Response to SCC Submission – dated 21/2/17 to assist DPE with finalising the assessment

TITLE: Landscape Layout Plan

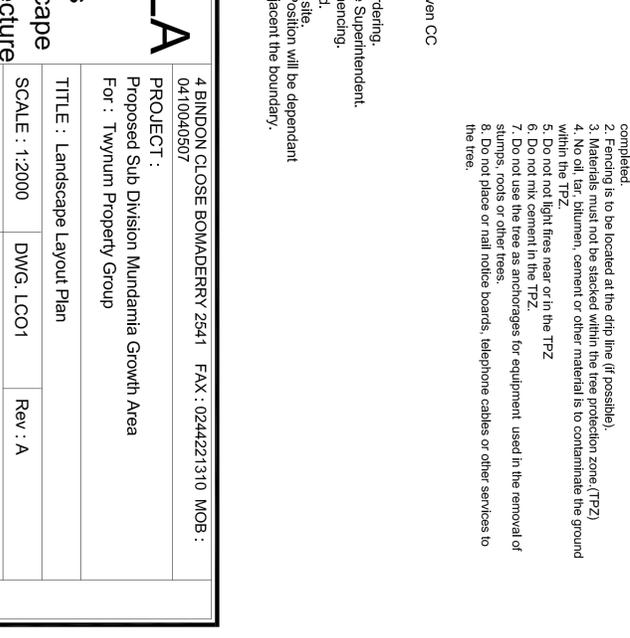
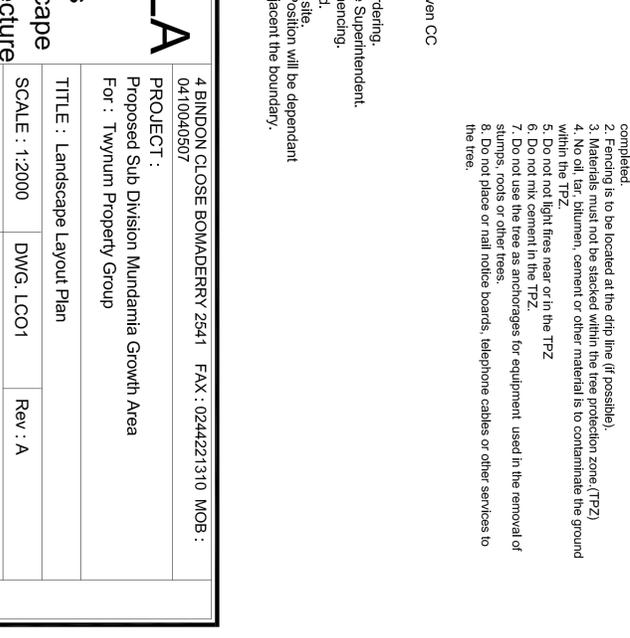
No turf	The requirement for no turf in certain areas is accepted and it is requested that this requirement be inserted as a condition of consent that is needed to be shown on a landscape plan that is approved by Council "prior to Construction Certificate".
	Landscape Plan	The requirement for an updated landscape plan is accepted and it is requested that this requirement be inserted as a condition of consent that is needed to be completed and approved by Council "prior to Construction Certificate".
Building Manager	BAL identifying plan	The requirement for a BAL identifying plan is accepted and it is requested that this requirement be inserted as a condition of consent that is needed to be completed and approved by Council "prior to Subdivision Certificate".
	Amalgamation of lot 726 into 725	<p>This request is not accepted.</p> <p>The attached APS drawing 25489-SK08 shows lot 725 along with the required APZ's to the east and south. The site has a building envelope that is 14m wide and in excess of 16m long. This is adequate space to construct a new dwelling on the lot. In addition, the drawing also shows two 4-bedroom – single storey dwellings with outdoor living space that easily fit within the allotment boundaries. The concept design for those project homes is attached and if future residents prefer additional outdoor space, modified house designs or many two-storey options exist.</p>
